From: Louise Crane
Sent: 23 March 2018 16:23
To: Planning.Responses
Subject: FW: Planning Consultation on: BE/17/18/PL

APPLICATION BE/17/18/PL

Site Address: 37 Norbren Avenue Bersted PO21 5HE

Description of Works: Proposed 2 bed bungalow

Proposed First Floor Plan

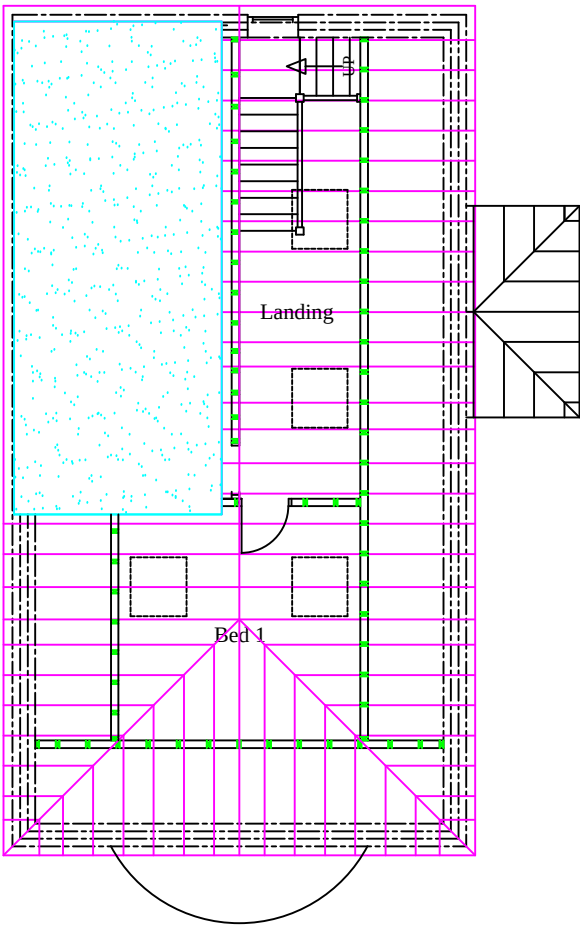
- Must meet the requirements of the Housing Act 2004 and be free of Category 1 and significant Category 2 Hazards;
- The first floor bedrooms - floor to ceiling height must be at least 2.1 metres from floor to ceiling over at least 50% of the floor area when measured at a height of 1.5metres from the floor and provide sufficient useable space.
